STATE OF NORTH CAROLINA
DEPARTMENT OF TRANSPORTATION

Subject: Request for Individual Permit Modification for NC 16 from north of SR 1386 in Lincoln County to North of SR 1895 in Catawba County. Federal Aid Project No. STP-F-24-1(34) State Project No. 8.1830501. \$475.00 Debit work order 34383.1.5. TIP Project No. R-2206C.

Reference: USACE Individual Permit dated October 7, 2004, Action ID 200420899. NCDWQ Water Quality Certification dated September 21, 2004, Individual WQC No. 3476.

CLEARING AND GRUBBING
EROSION CONTROL FOR
CONSTRUCTION SHEET 13

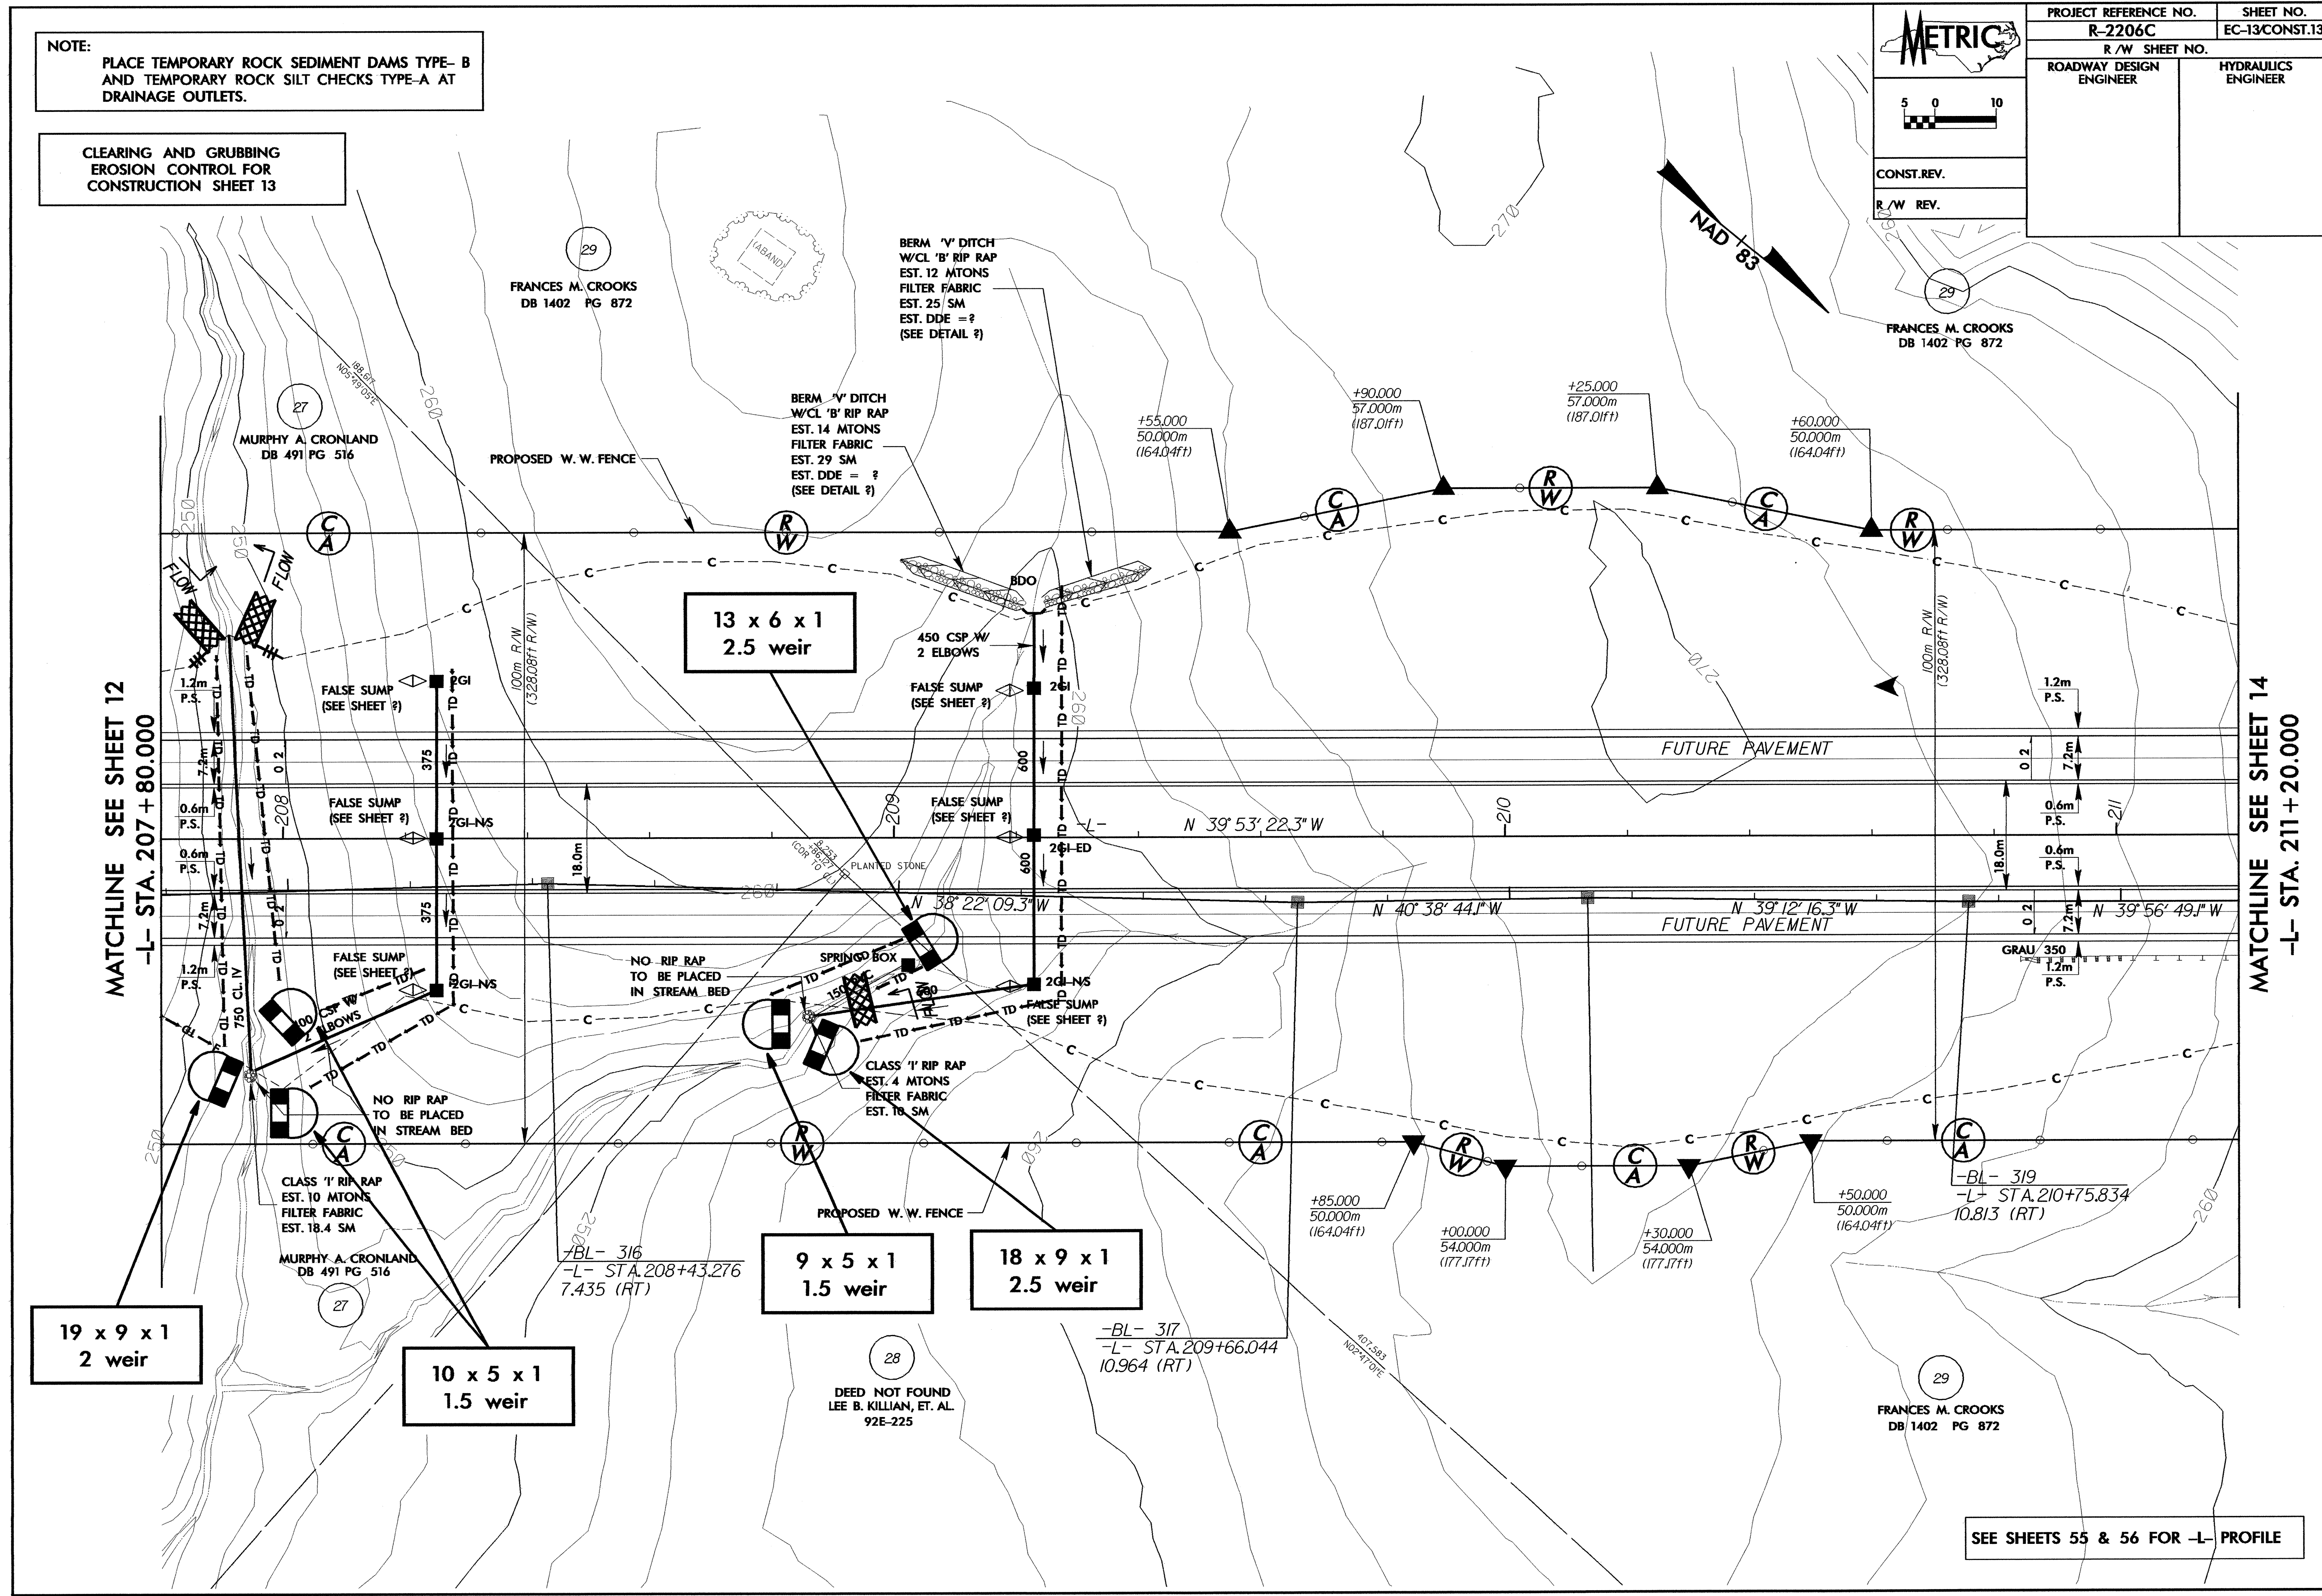
On May 17, 2005, during an on-site review of permitted sites, it was discovered that the 1050 mm pipe outlet at permit site 9C (Station L-211+68 to 211+95) was perched and not buried the required 20%. The Division Construction Unit proposed that a multi-pool energy dissipator with grade control be installed along with riprap armoring of the bank opposite the outflow. These structures were constructed on the same day and 32 linear feet of channel were permanently impacted.

The NCDOT respectfully requests that the referenced 404 USACE Permit (and Modification) and 401 Water Quality Certification (and Modification) be modified to reflect the revision to the natural stream design outlined in this letter. In compliance with Section 143-215.3D(e) of the NCAC, NCDOT will provide \$475 to act as payment for processing the Section 401 certification modification application previously noted in this application (see Subject line). We are providing seven copies of this application to the North Carolina Department of Environment and Natural Resources, Division of Water Quality for their review.
